26th June 2025

OBJECTION TO PLANNING APPLICATION FOR ERECTION OF TWO STOREY SIDE EXTENSION, SINGLE STOREY FRONT/REAR EXTENSION, FIRST FLOOR BALCONY AND ASSOCIATED ALTERATIONS

MOORLANDS CRICKET CLUB, MIRFIELD MEMORIAL PARK, HUDDERSFIELD ROAD, MIRFIELD, WF14 8AE

LPA REF: 2025/90956

PROPOSED FRONT ELEVATION
1:50

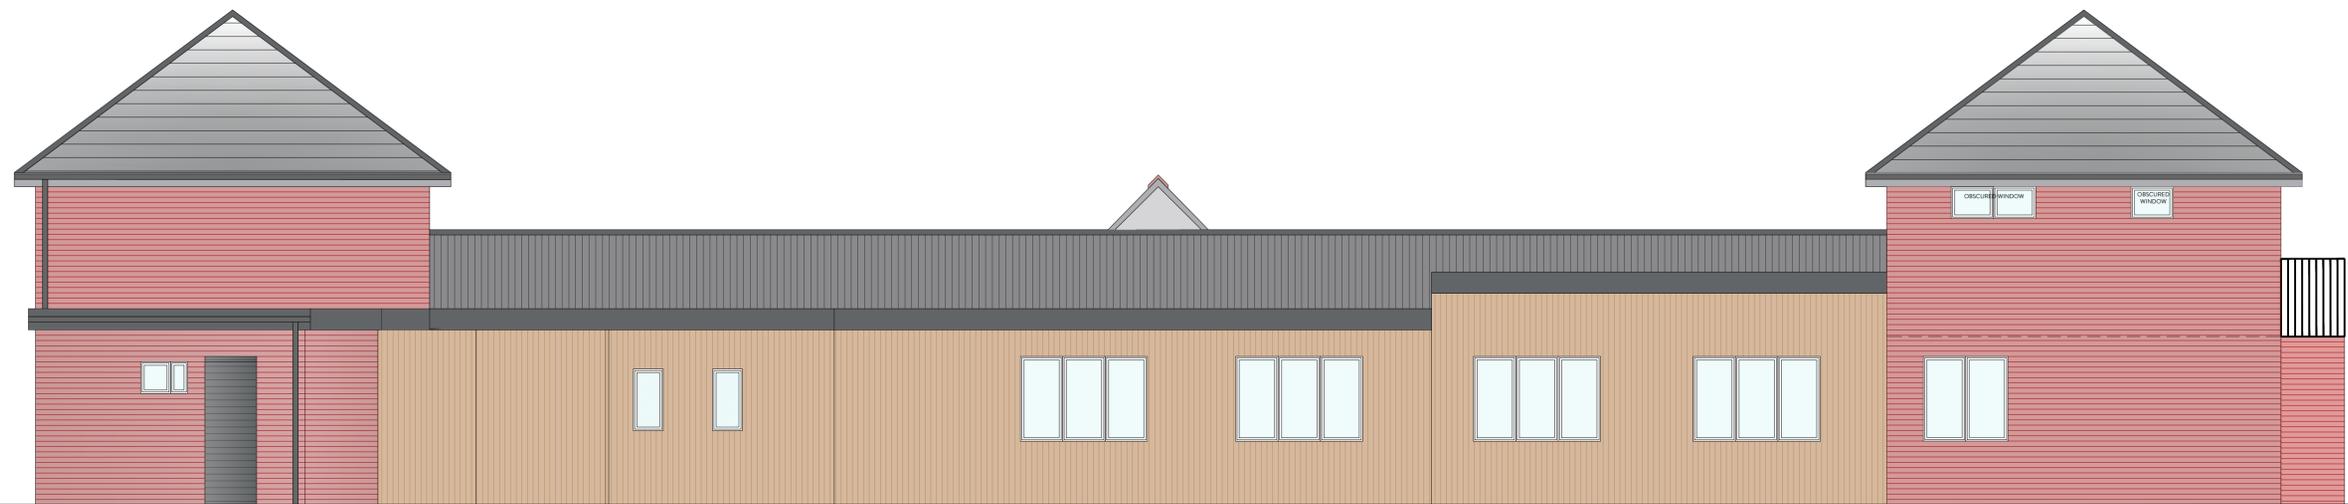
The proposed extensions and alterations to the clubhouse would bring the built development closer to the site frontage and war memorial. As a result, part of the memorial would be overshadowed by the development causing harm to the significance of the non-designated heritage asset. The applicant has not made any reference to the war memorial / gateway in their application and has therefore not argued that any benefits the development may have outweigh the harm caused.
